**Application Reference:** 6/2017/2160/COND

**Proposed development at:** Mercury House 1 Broadwater Road Welwyn Garden City AL7 3BQ

**Proposal:** Submission of details pursuant to condition 1 (materials samples), 2 (soft and hard landscaping), 6 (bin stores) and 7 (cycle stores) on planning permission 6/2016/2624/FULL

Drawing
Proposed Bin Store

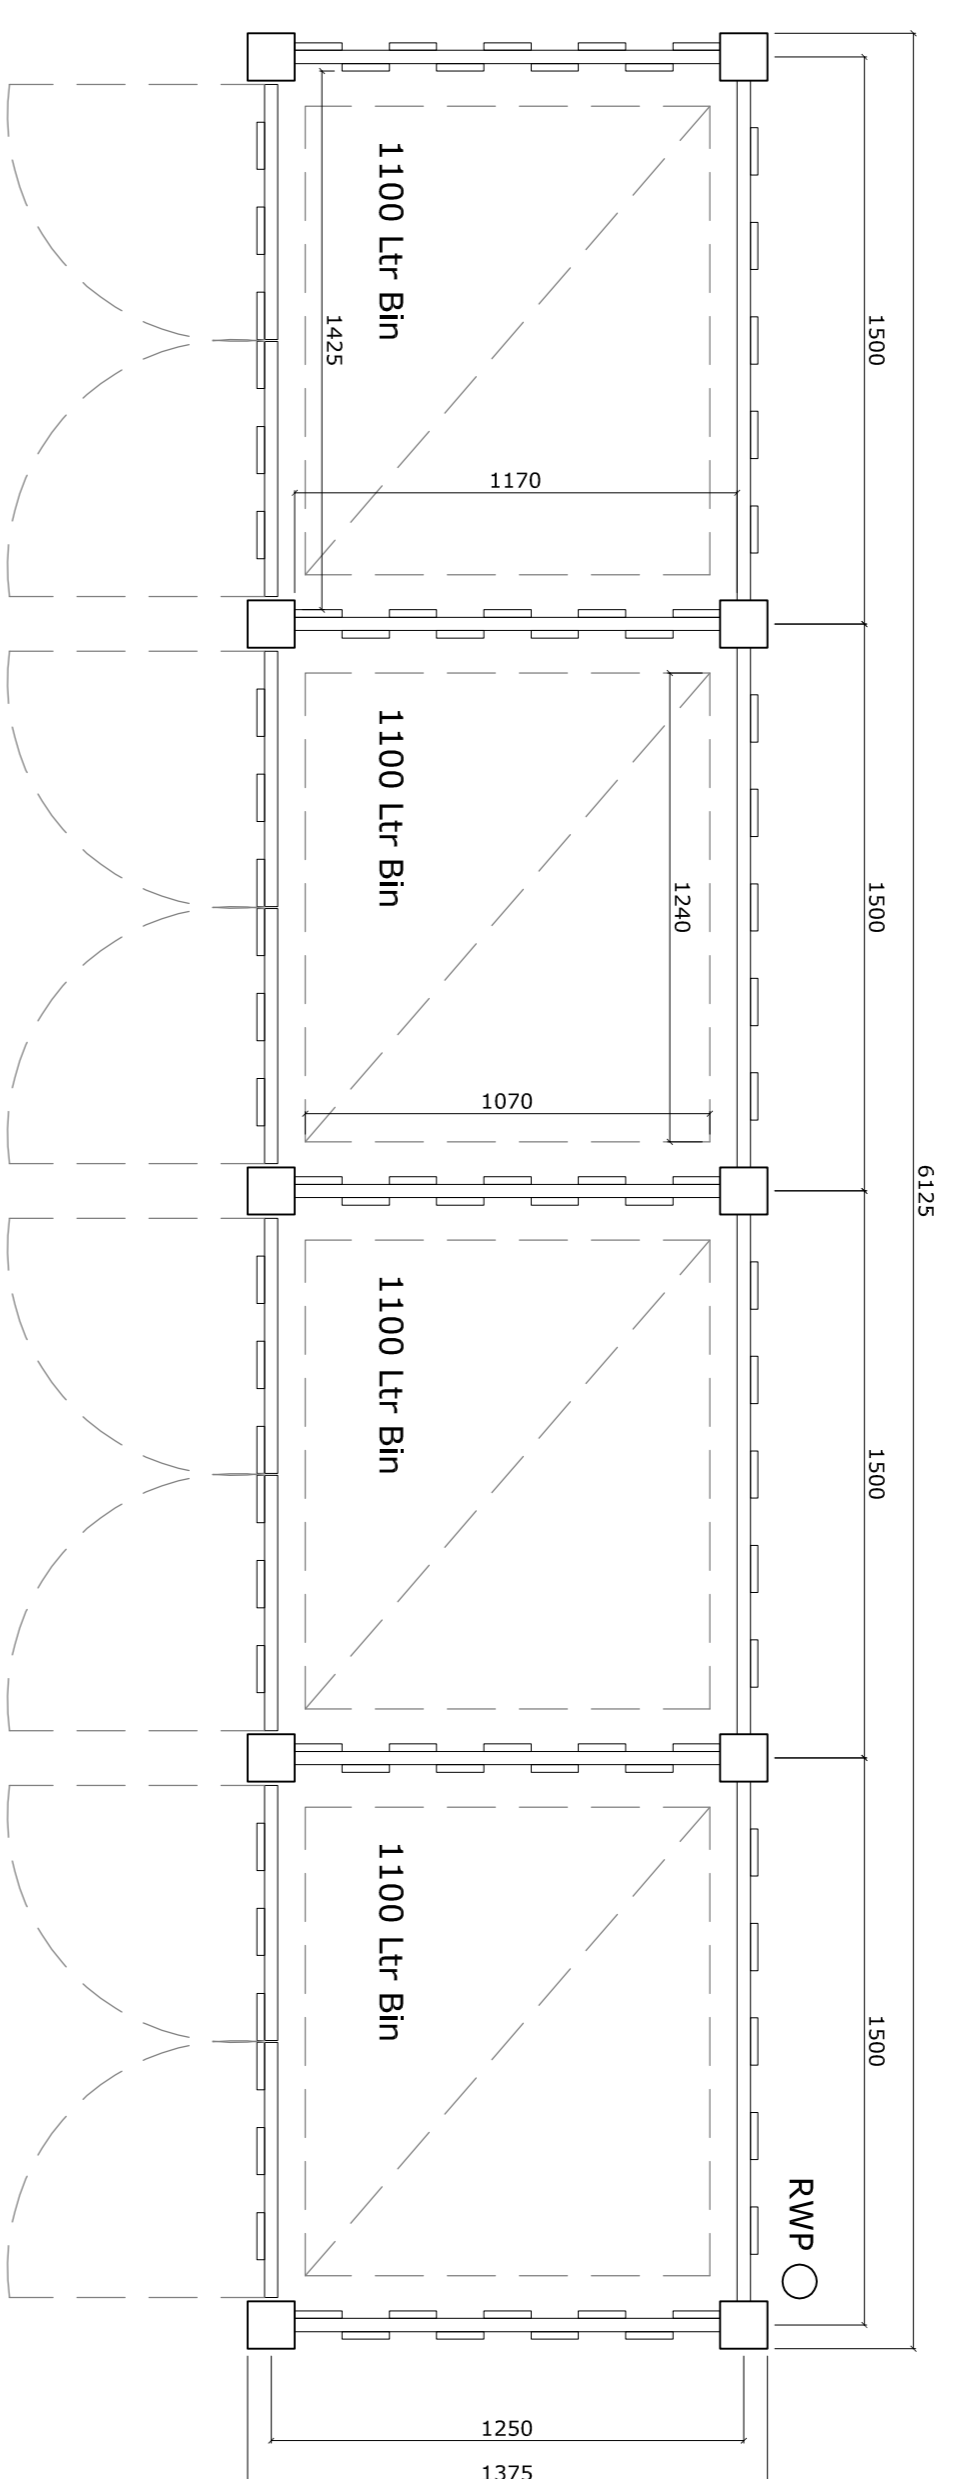
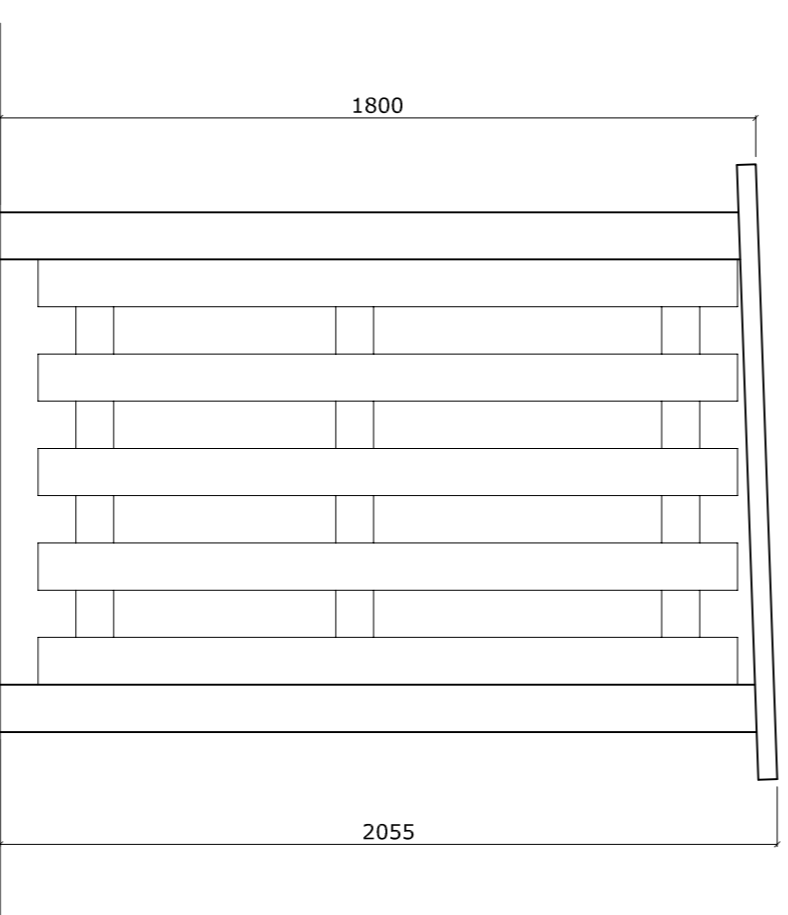
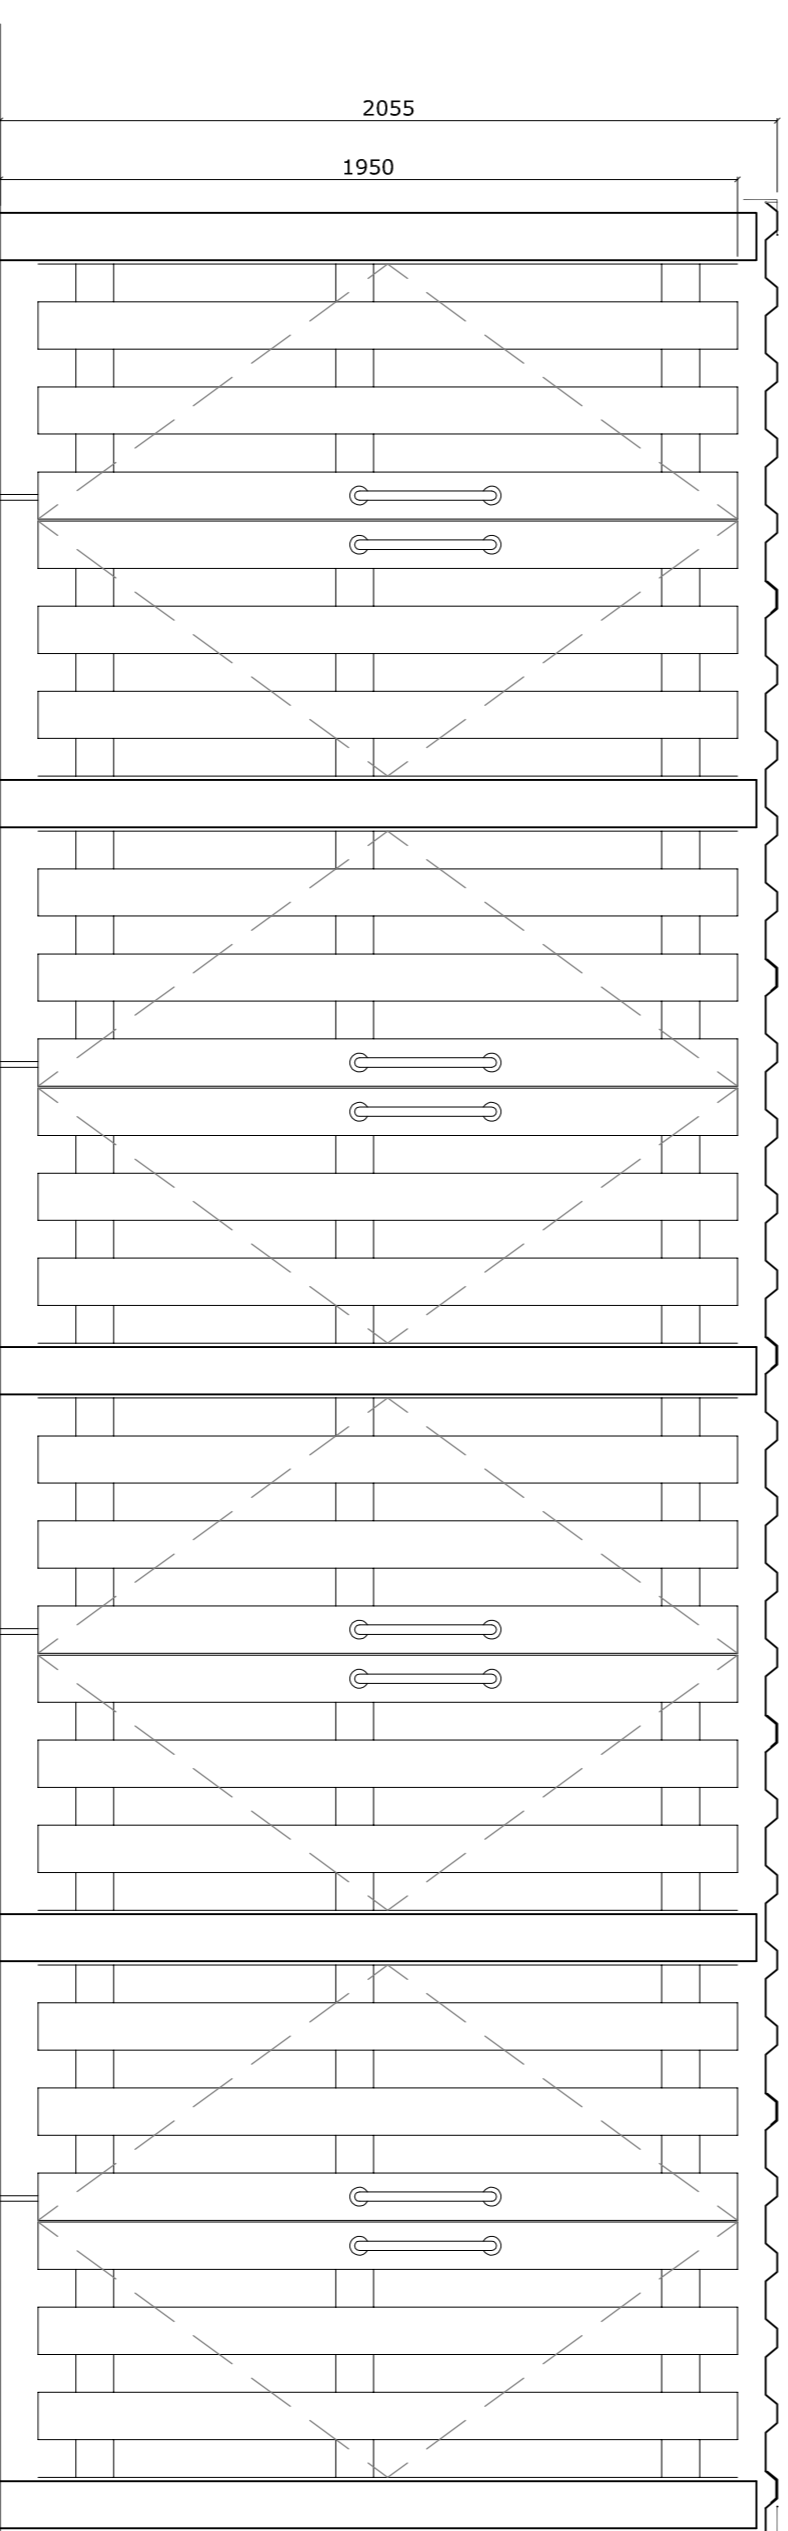
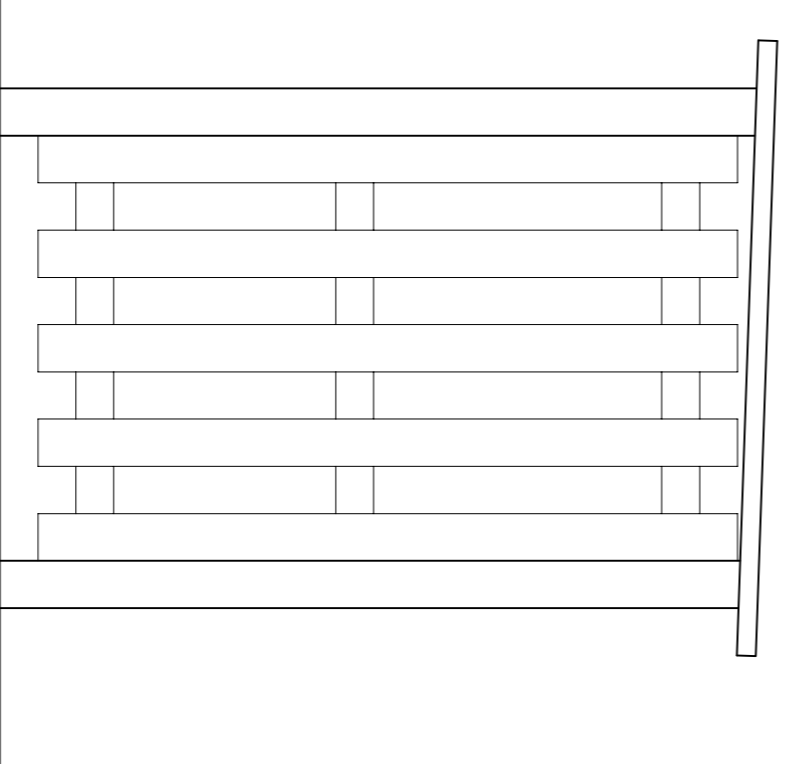
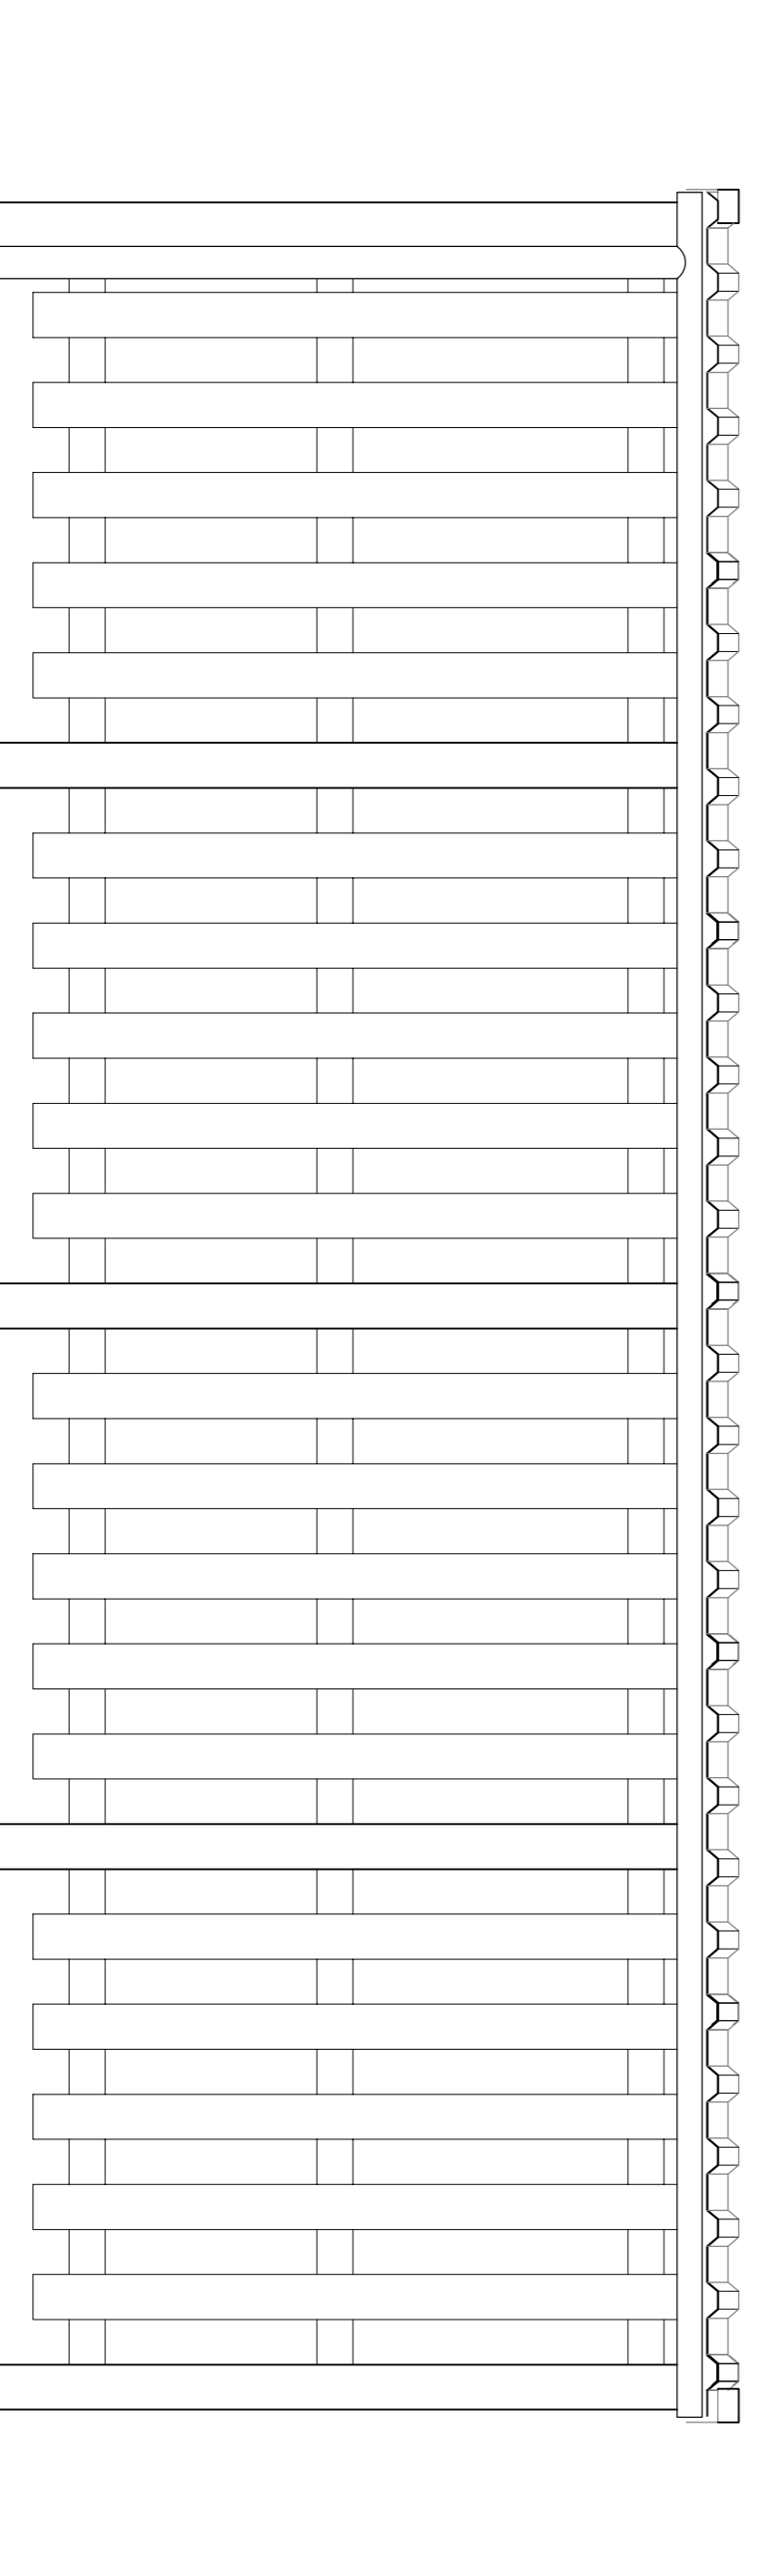
Whilst no objections are raised regarding the appearance of the bin stores, comments from Client Services have recommended that only 2 x mini recycling backs are required and are stored in one bin store with double doors. Furthermore the access for the bins to be wheeled to the collection point should be a minimum of 2m wide. It is advised that once these changes have been made no objections would be raised.

Drawing  
Proposed Cycle Store

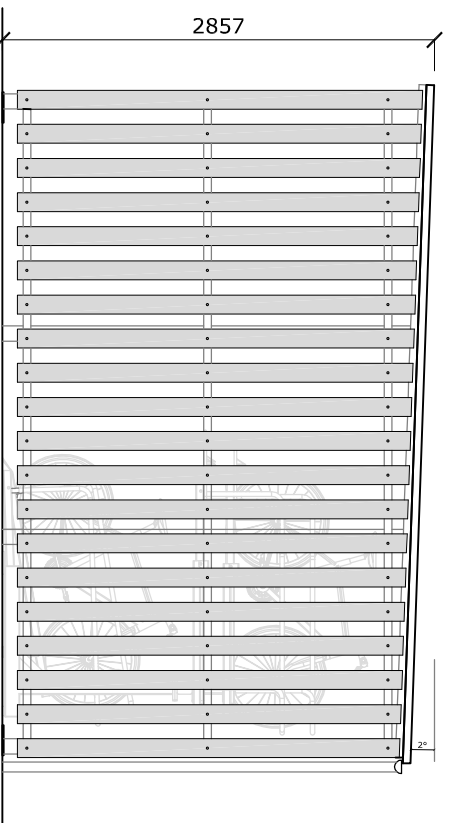
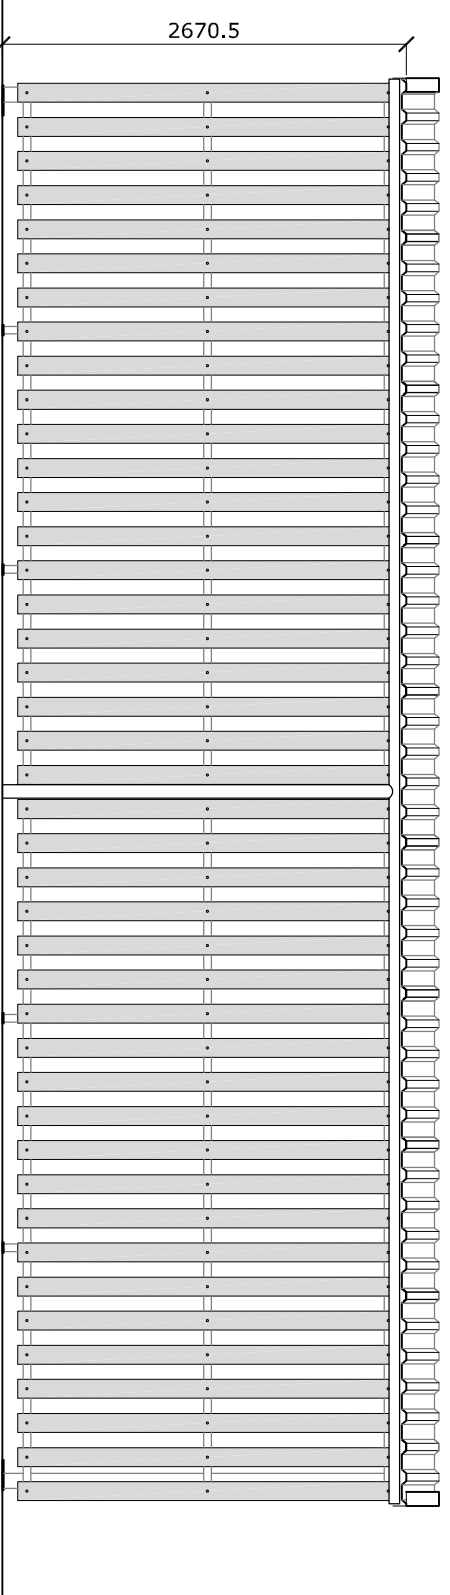
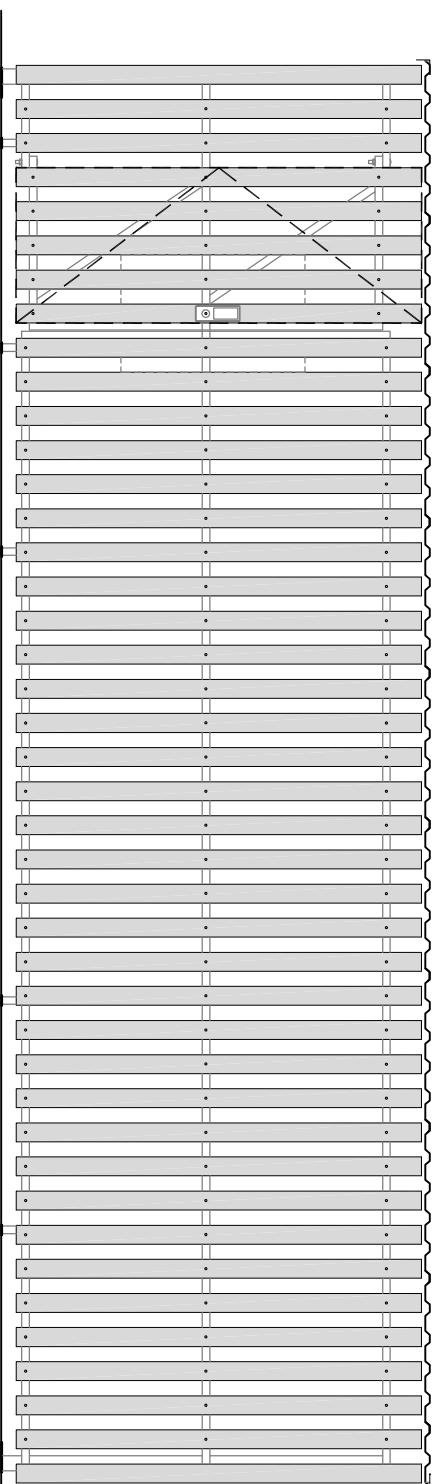
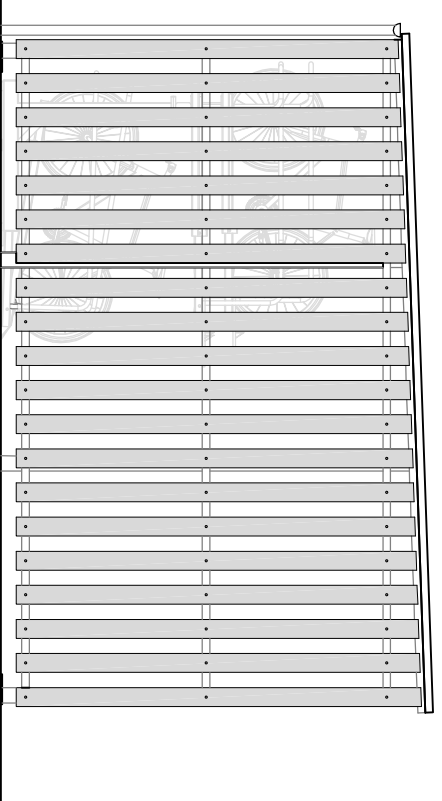
Whilst the wooden material is considered acceptable, the metal roof is not considered to be acceptable and would be readily visible within the public realm. It is advised that either a different material is sought for the roof or a metal roof is obscured.
